Department of Primary Industries

Moorebank Intermodal Terminal (SSD_5066) Comment on the Response to Submissions Report

Moorebank Intermodal Terminal project (SSD-5066) Comment on the Response to Submissions Report Comments by DPI Water

Figure 8.1 Location of proposed biodiversity offset areas

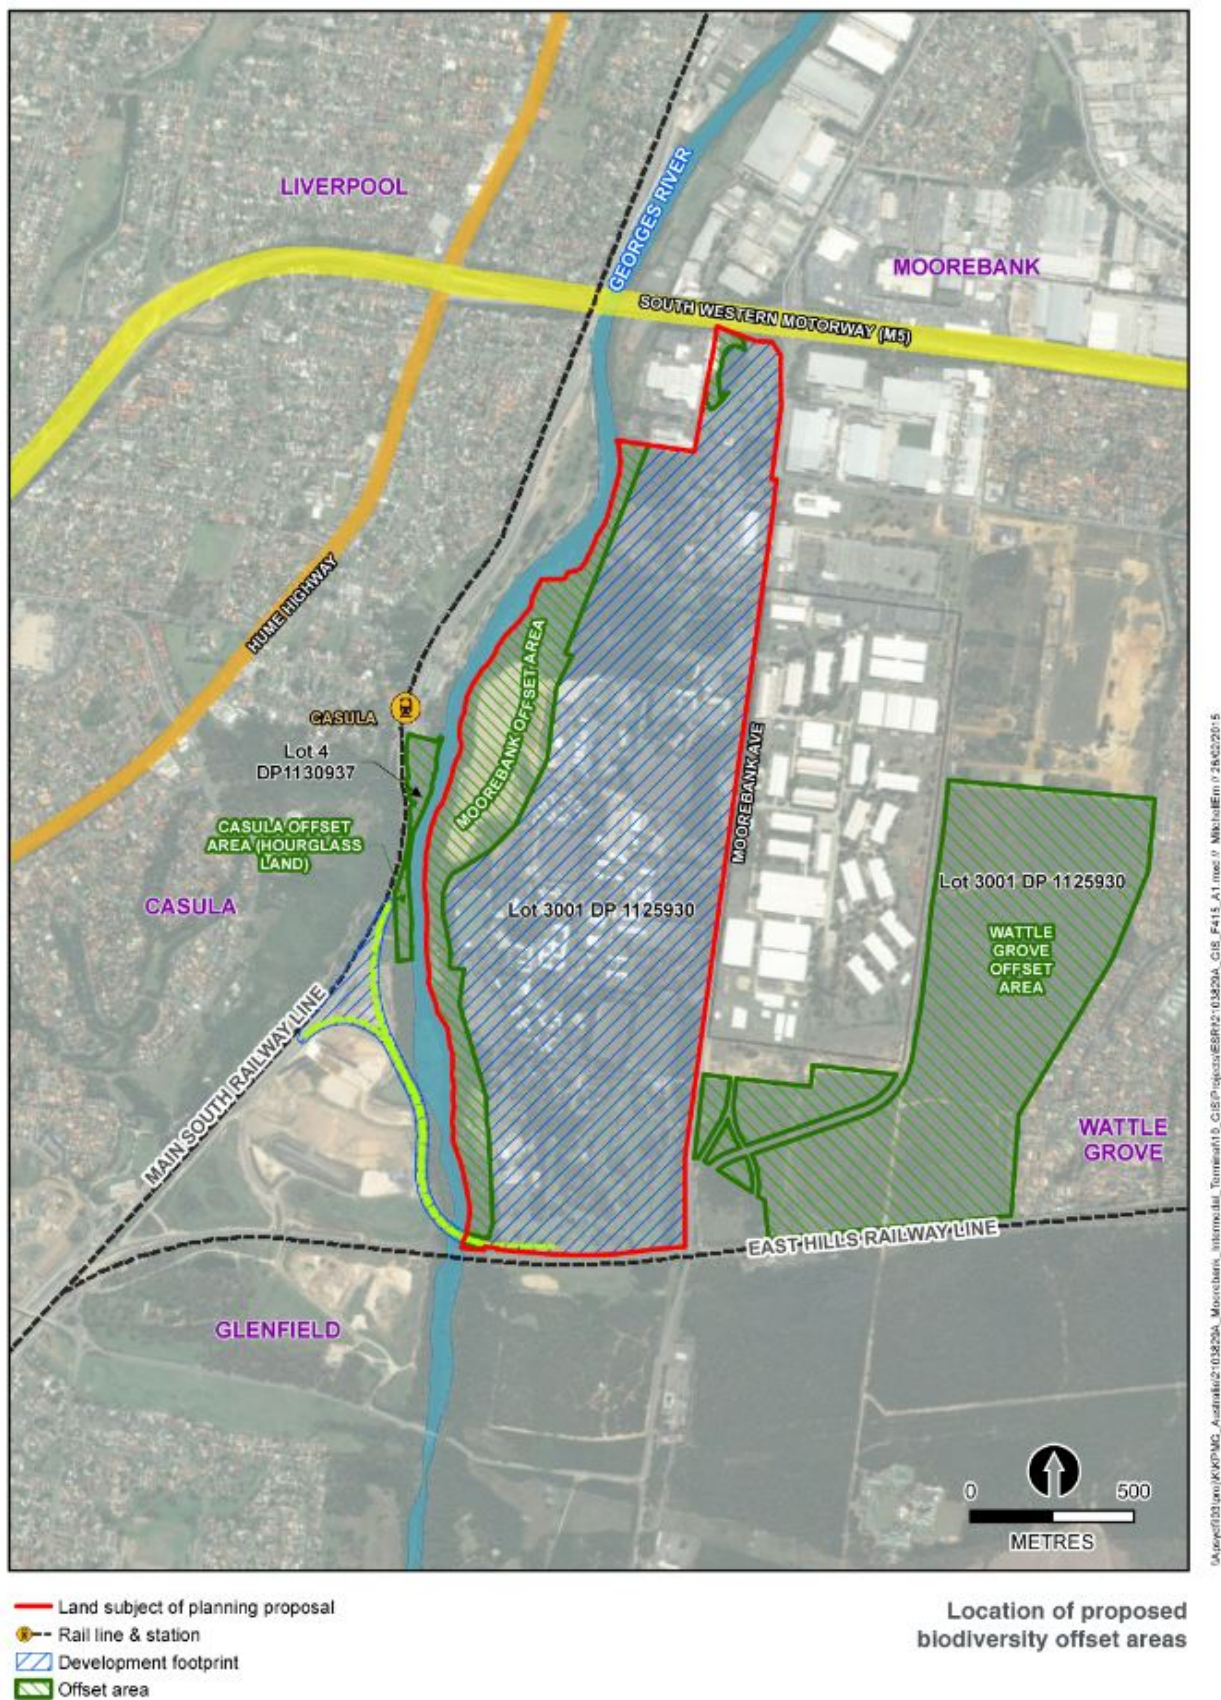
Figure 8.1 in the RTS shows the proposed biodiversity offset areas, including those proposed along the Georges River (page 287). The Casula offset is located predominantly to the north of the southern rail link on the western side of the river. As the southern rail link extends along the western side of the River adjacent to remnant native vegetation, clarification is required as to why this area is not included to offset impacts and what this means in terms of protecting and rehabilitating this section of the riparian corridor. Appendix C of the RTS indicates the vegetation on the western bank within and adjacent to the Glenfield Waste Services is in poor condition and weed infested (page 15). It is recommended the SDD-5066 and SSD-6766 projects rehabilitate this section of the riparian corridor

Figure 7.2 Revised Project layout at Full Build (2030)

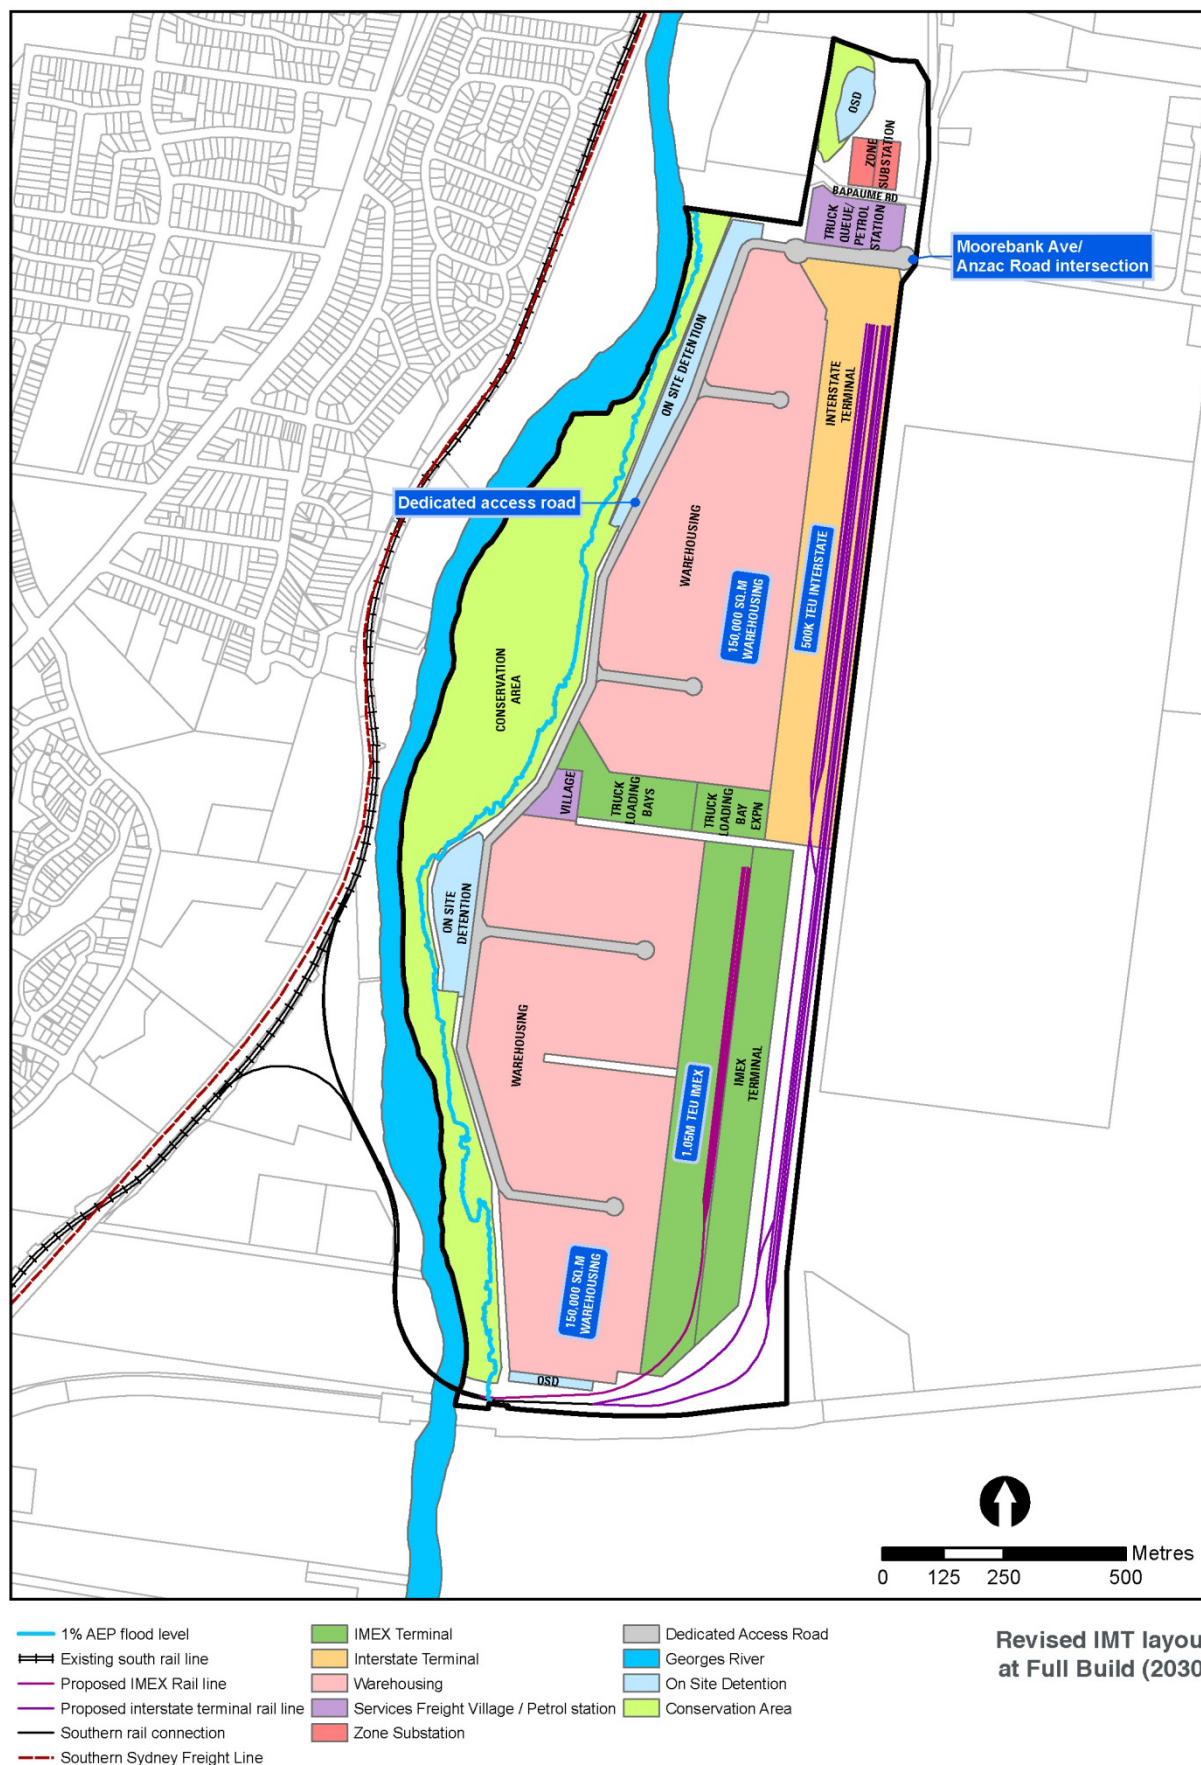
Reductions in the width will impact on riparian connectivity function. It is recommended a Condition of Approval is included which outlines the minimum width to be established along the Georges River. Figure 7.2 (Revised project layout at full build) in the RTS may need to be amended depending on the minimum width required to be established.

Depending on the minimum width required to be established at the site, the narrower sections along the Conservation Area/ riparian corridor as shown in Figure 7.2 of the RTS may need to be widened. It is noted the Indicative layout would be further developed and details would be provided as part of the Stage 2 SSD applications (Appendix B of RTS) but it is recommended the issue of the minimum riparian width is resolved as part of this project and a Condition of Approval is included to clarify the minimum width to be established.

The EIS for SSD-5066 indicates Anzac Creek would be removed and the flows are to be redirected through stormwater detention basins on the site (Technical Paper 3, Section 4.2.1.4, page 85). Figure 7.2 in the RTS shows development in this location rather than the rehabilitation of the creek and the riparian corridor.

Management Measure 6Z requires a riparian restoration plan for the Georges River riparian zone and Casula offset area to be implemented which includes widening of the existing vegetation corridor where feasible. While the Management Plan for Restoration of the Riparian Zone of the Georges River includes an action to restore and revegetate the riparian zone to be consistent with and complementary to areas of remnant indigenous vegetation within the Georges River Corridor it does not include details on the riparian widths that are proposed to be restored along the river. Management Measure 6Z needs to identify and clarify if the riparian corridor equates to the Conservation Area which is shown on Figure 7.2 (Revised project layout at full build) in the RTS.

- incorporate provision for light and moisture penetration under the bridge structure to enable plant growth.
- 3 The minimum width of the riparian corridor to be protected and rehabilitated along either side of the Georges River within the project site and adjacent to the southern rail crossing will be consistent with the Final Statement of Commitments for MP10-0193
